RE: John Street Pond Feasibility Design Analysis Report
Engineer's Stamp Date: 11/09/23
Hydrology File: L14D067

COMMENT RESPONSE LETTER

RE: John Street Pond Feasibility Design Analysis Report
Engineer's Stamp Date: No date
Hydrology File: L14D067

JOHN STREET POND FEASIBILITY DESIGN ANALYSIS REPORT

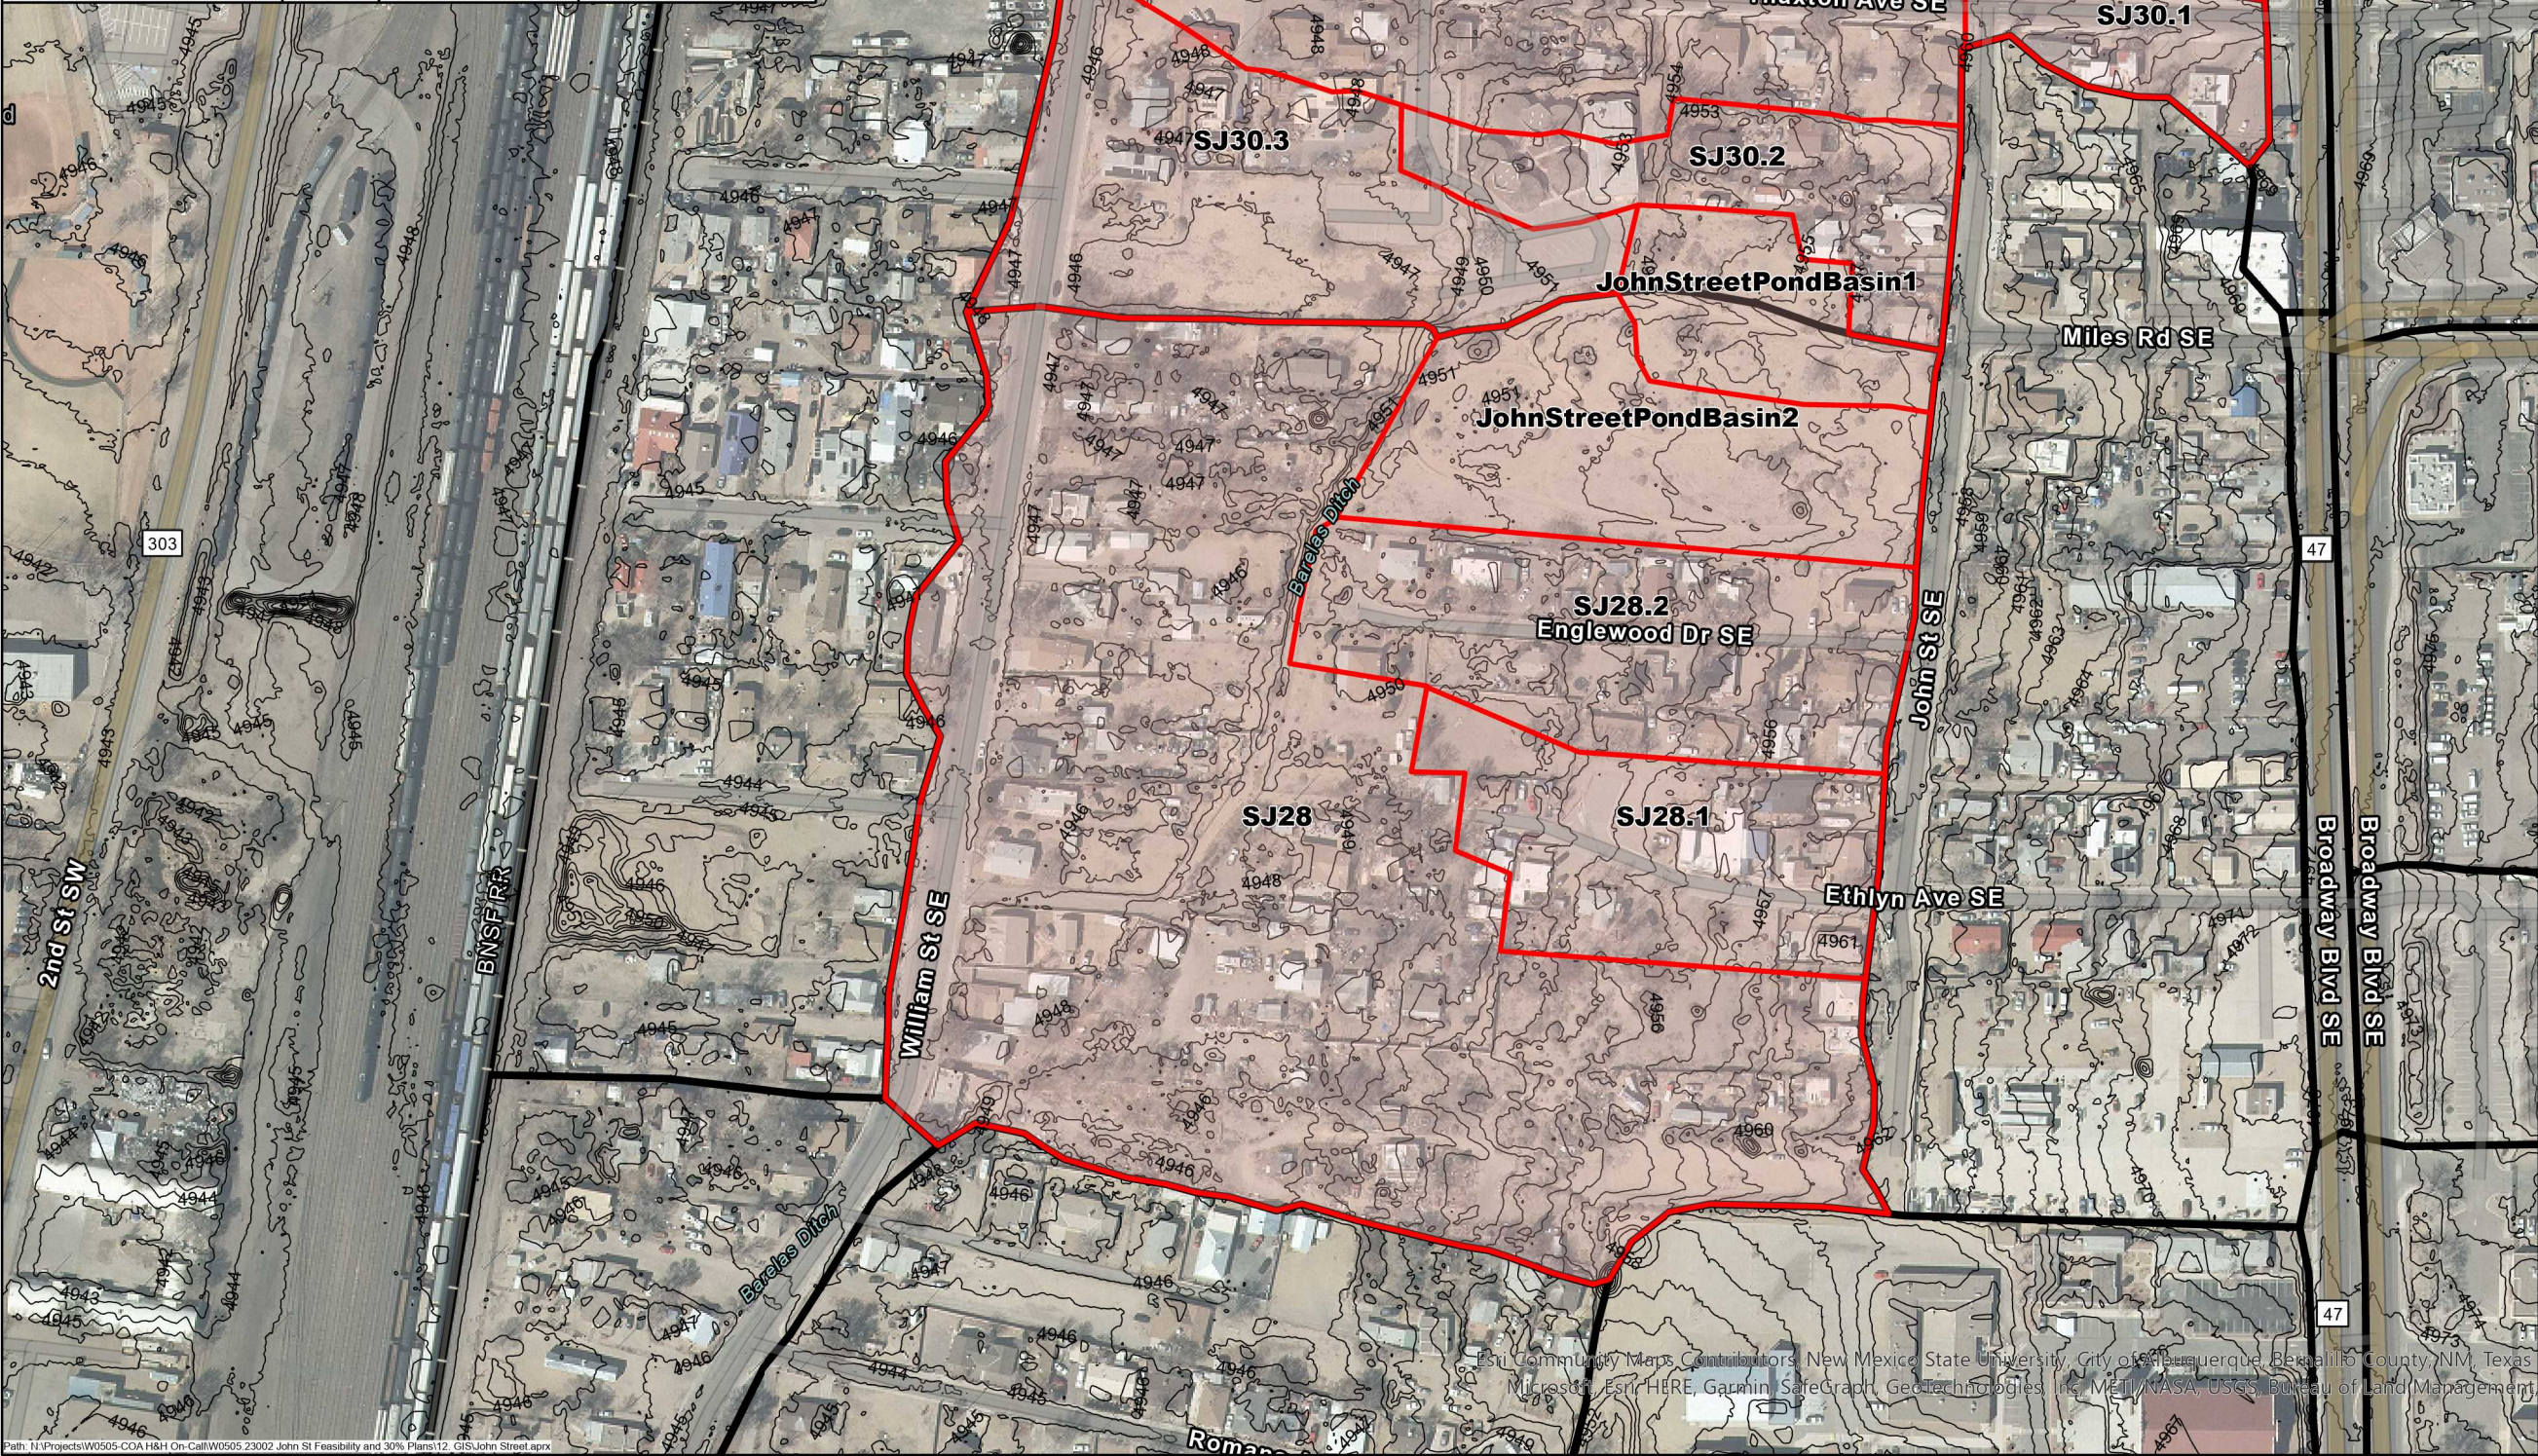
4. In 2.2 Proposed Conditions, why are all the Curve Number (CN) the same? Hydrology section has found if you are using a soil map within Albuquerque, then the resulting flows are off. As in the DPM, Hydrology Section recommends using the following CNs depending on the land treatment and using a weighted CN.

- a. The use of just four Curve Number (CN) values, one for each of the land treatments already described in the DPM: A=76, B=80, C=85 and D=98. This way the hydrologic soil groups don't need to be determined to select the CN and the soil maps do not need to be consulted.

- b. For example, John Street Pond Basin 1 has 85% impervious but uses a CN 86. If you use a weighted CN, then you get $0.85 \times 98 + 0.15 \times 85$ which gives a CN 96.

c. For example, John Street Pond Basin 2 has 20% impervious but uses a CN 86. If you use a weighted CN, then you get $0.20 \times 98 + 0.80 \times 85$ which gives a CN 87.6.

As you can see using the weighted CN gets a more accurate representation of the existing conditions or proposed conditions. RESPEC maintained the same hydrology procedures discussed in the Alameda SWMM Drainage Study (October 2022) report, which is also referenced in the South Broadway DMP (March 2023). The Alameda SWMM Drainage Study discusses in depth the hydrology practices and curve number (CN) selection. Below is a screenshot of verbiage from the Alameda SWMM Drainage Study report for context. The subarea routing method used, from the SWMM hydrology manual, was the "impervious method" which routes the directly connected area (roofs to driveways into the street into the storm systems) over pervious area (grass, compacted parking lots, etc.). Since the area around John Street Pond has similar lot sizes, the CN selected was applied to the pervious area of the subbasin. Since the Hydrologic soils report showed a mixture of groups A-D for the watershed, RESPEC conservatively used CNs in HSG C since the drainage area is developed with compacted pervious soils. Therefore, for these lots around the John Street area, RESPEC used an average CN of lot sizes 1/8, 1/3 and 1/4. RESPEC will provide the Alameda SWMM Drainage Study report.

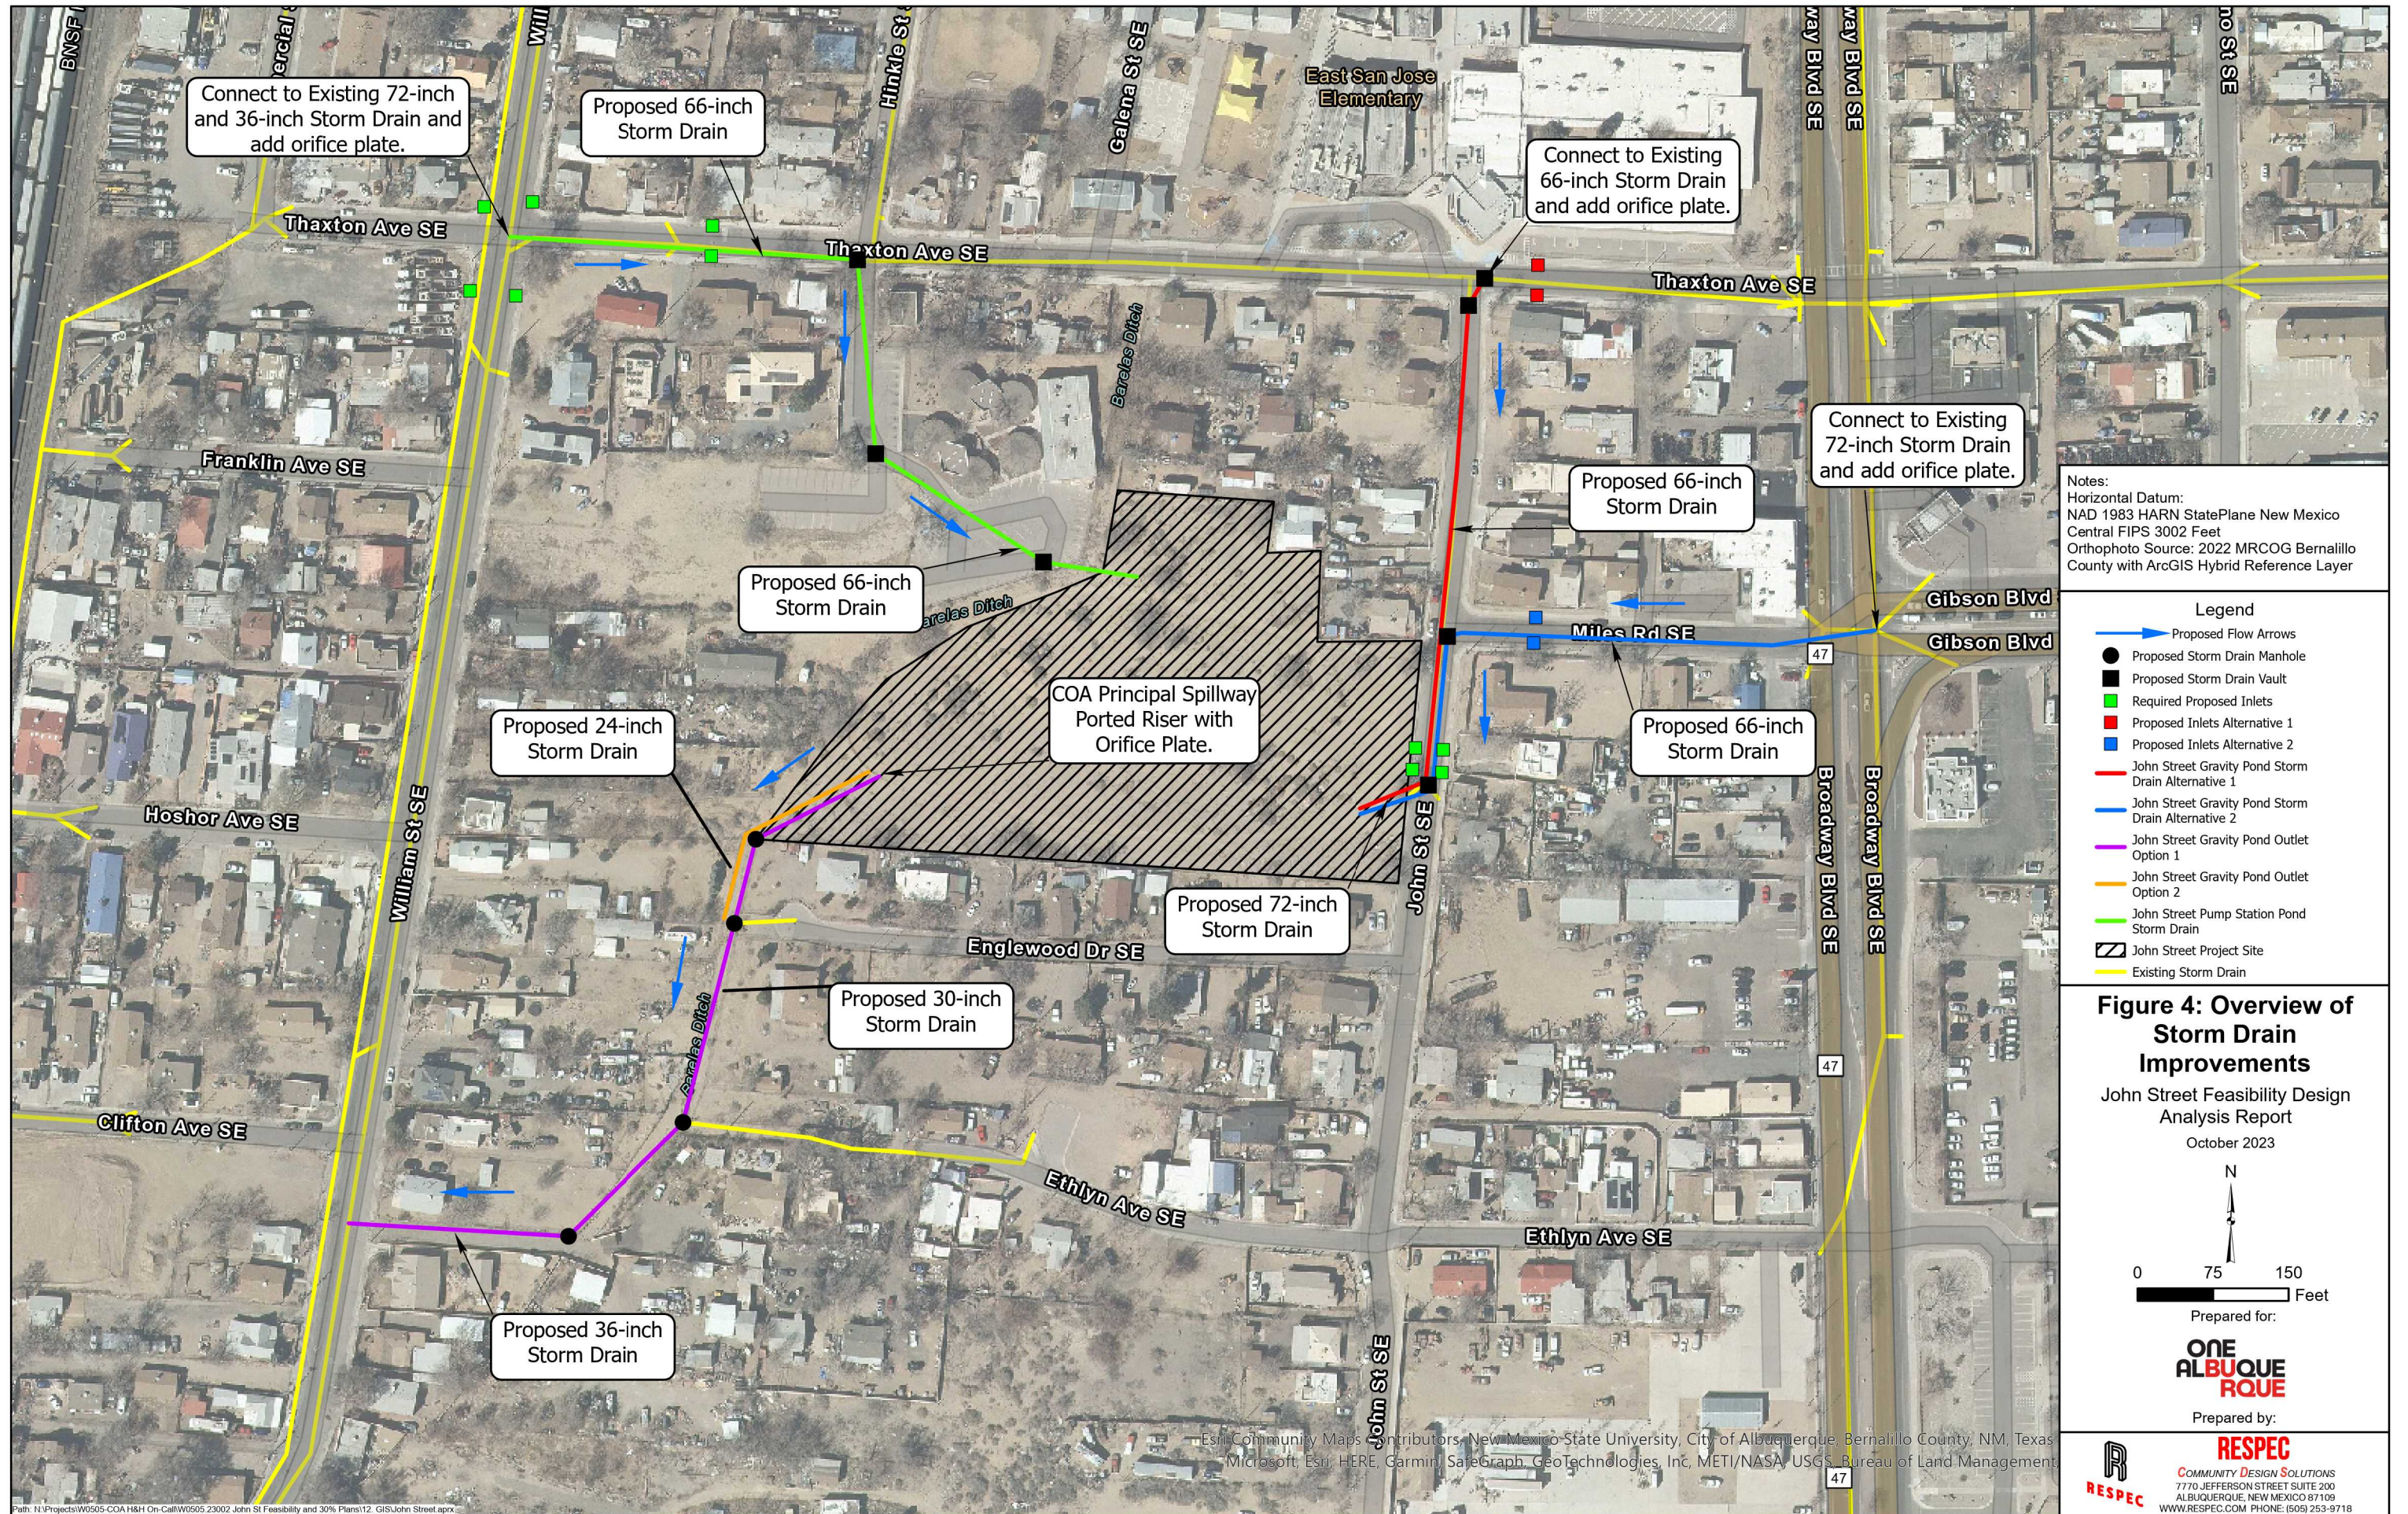
5. Figure 4, Overview of Storm Drain Improvements. It would be very helpful if you include the Q100 at the storm pipe for both the existing and the proposed on the map. (See below) This should be help explain how the whole proposed system will help with the capacity in the existing storm drain by the proposed detention & pump station.

[These were added to the figure.](#)
